# CITY OF ALBUQUERQUE

**Re: Longhorn Steakhouse, 9975 Coors Bypass NW  
Request Temporary C.O. – 180 day Accepted  
Engineer's Stamp dated: 12-16-13 (B13D003A2)  
Certification dated: 4-23-14**

GRADING & DRAINAGE PLAN

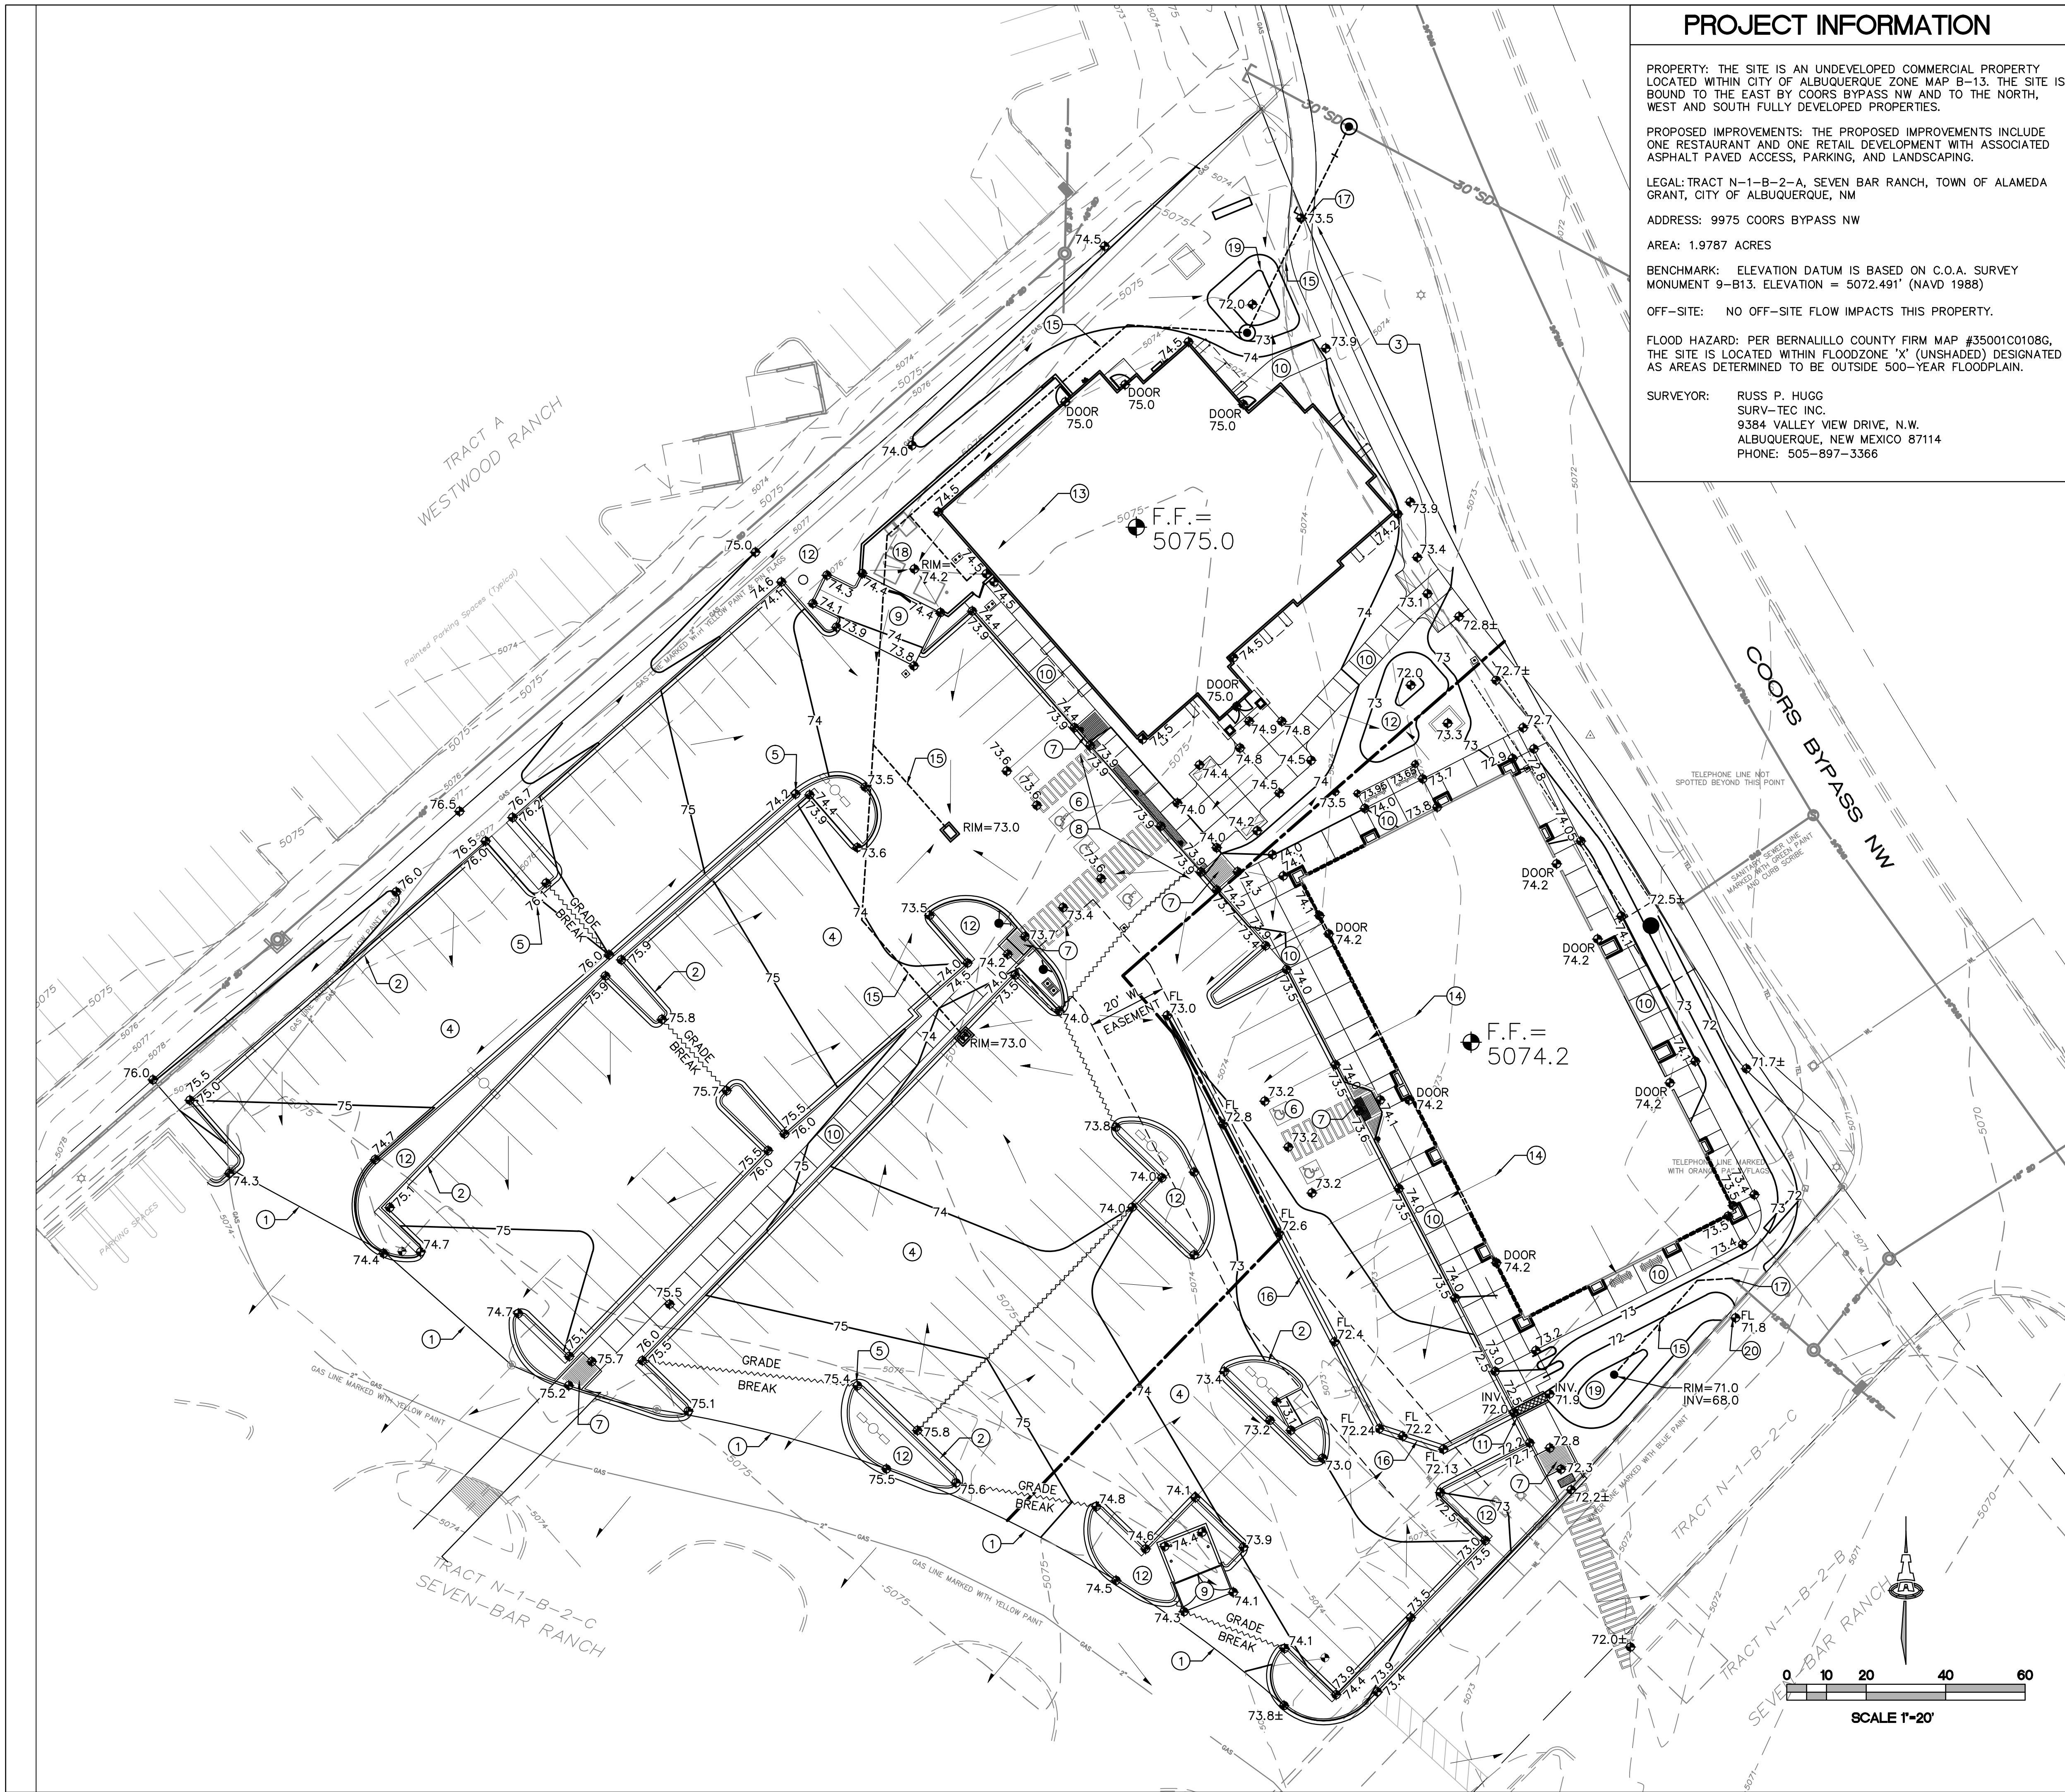
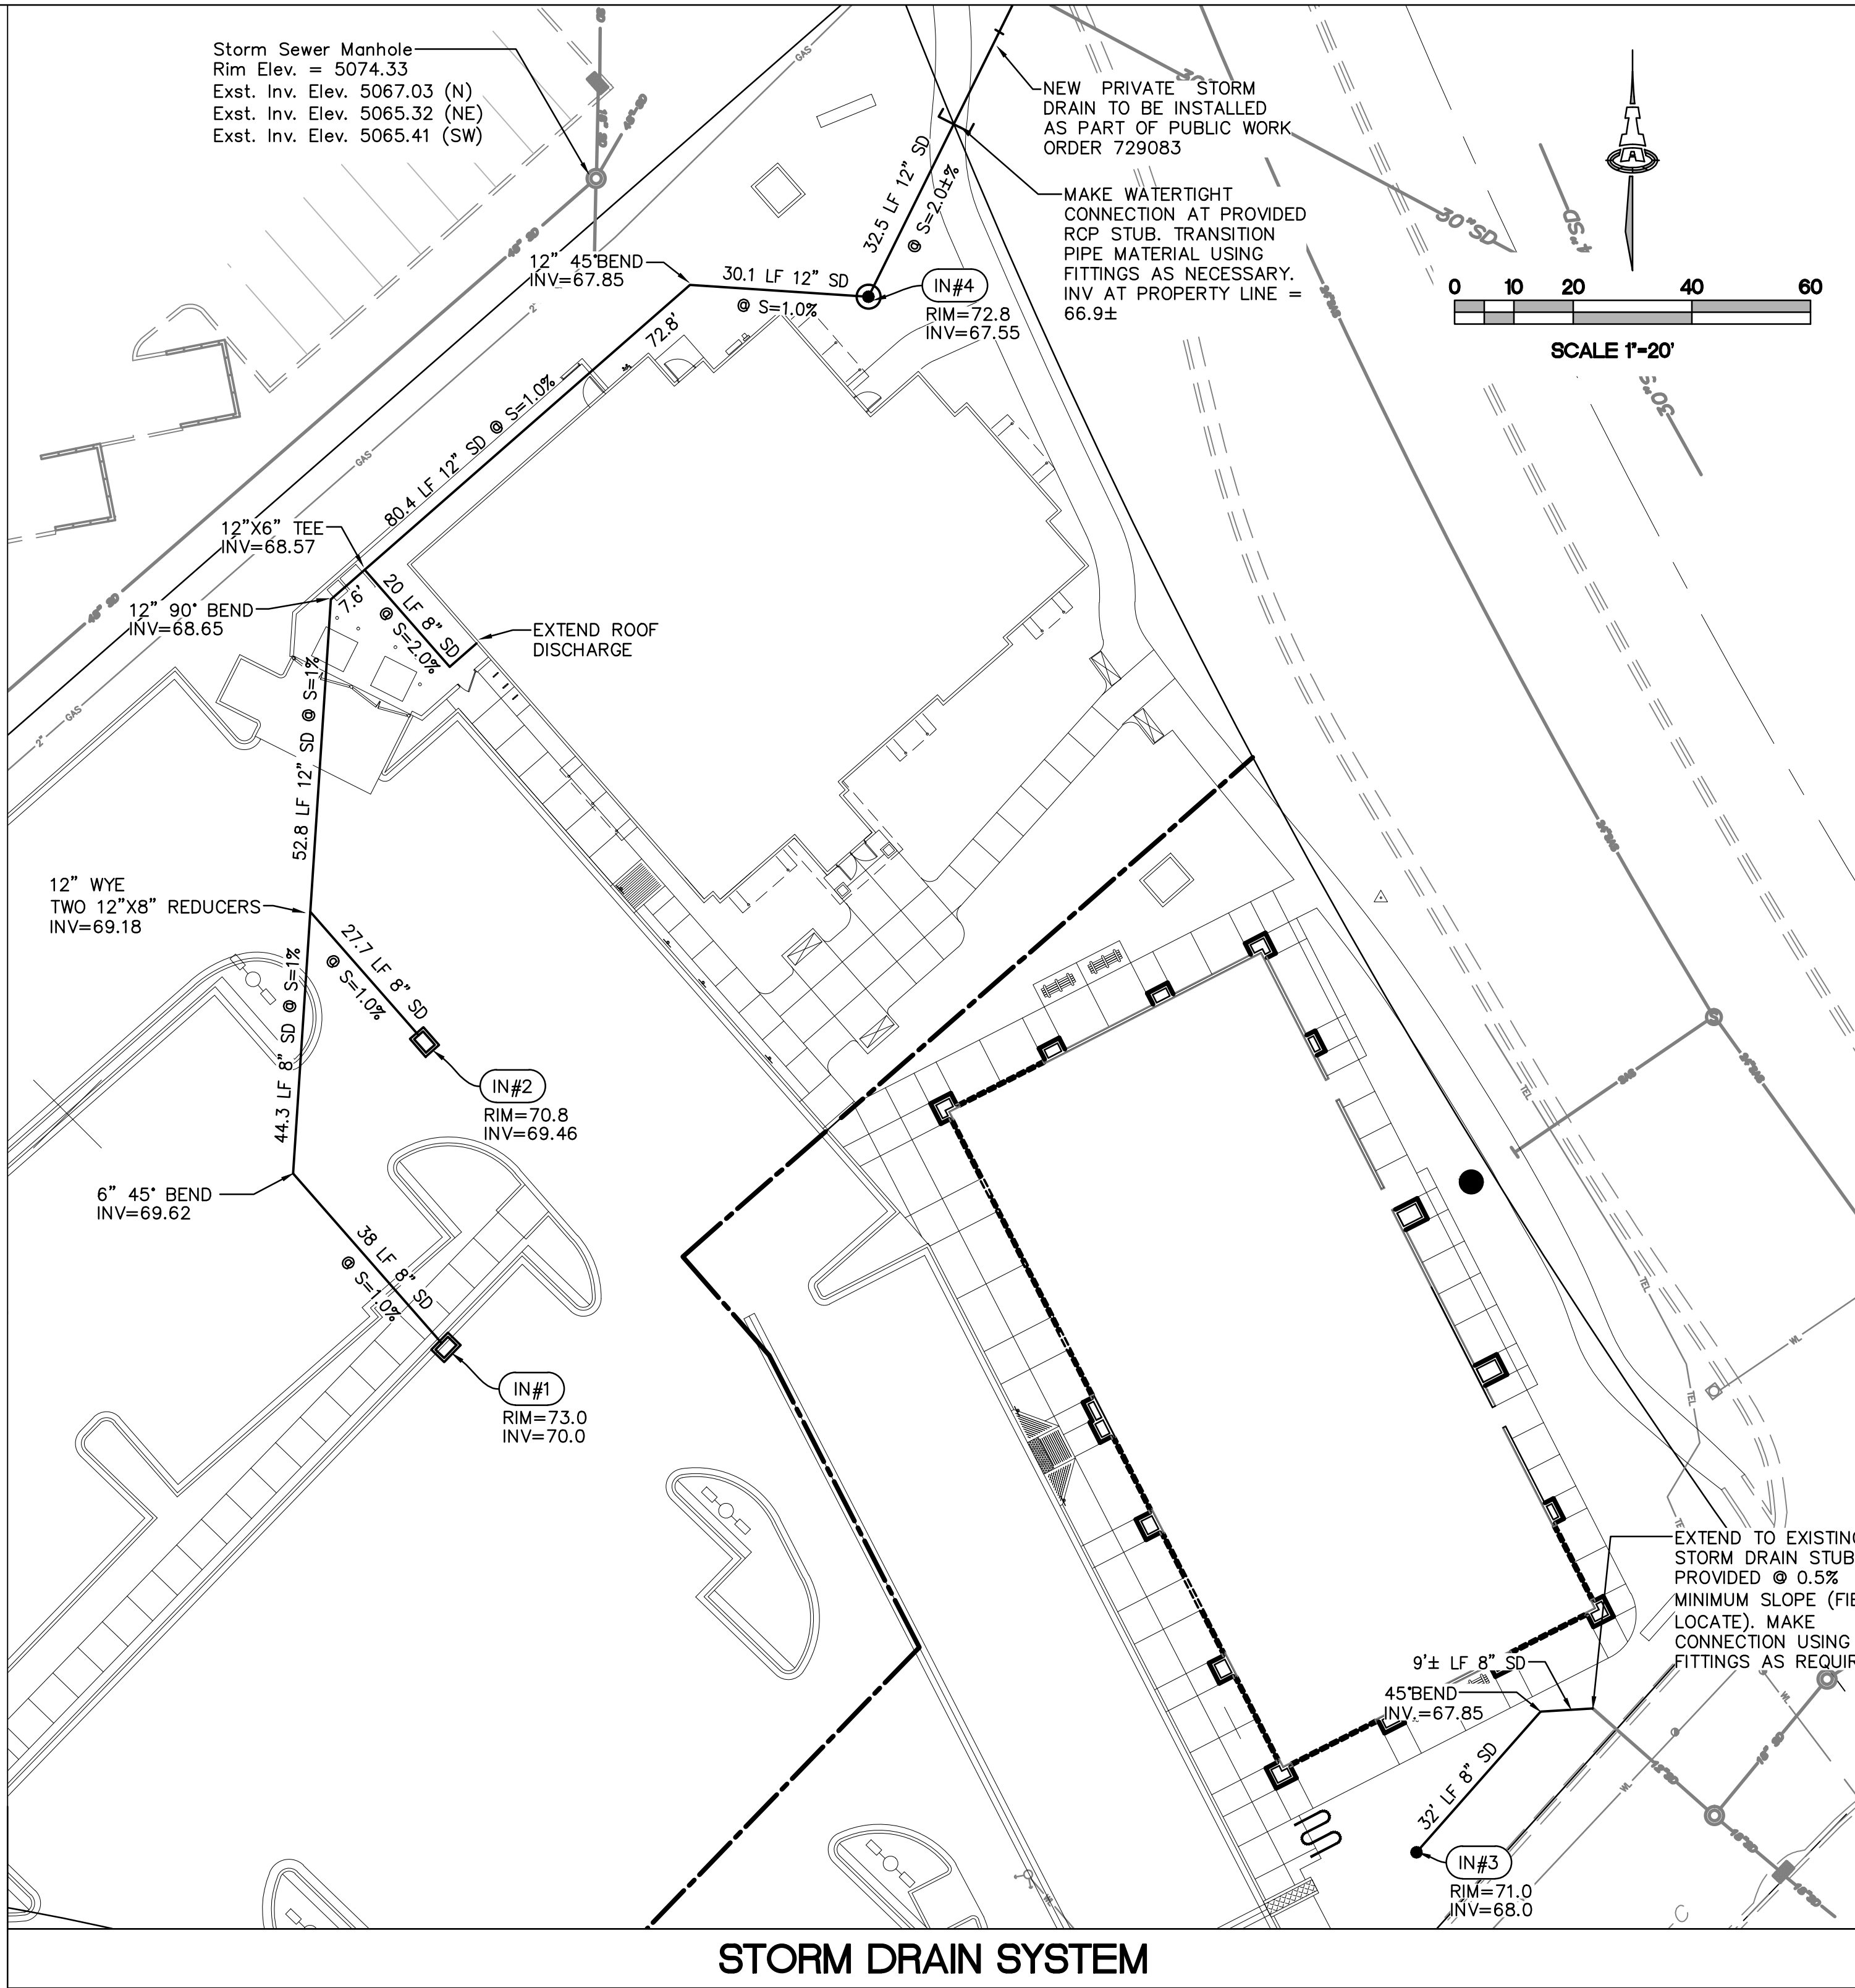
However, before a permanent Certificate of Occupancy can be accepted the following comment must be addressed. The area to the west of the building needs to show that flows are being directed toward the inlet on the North West corner of the property.
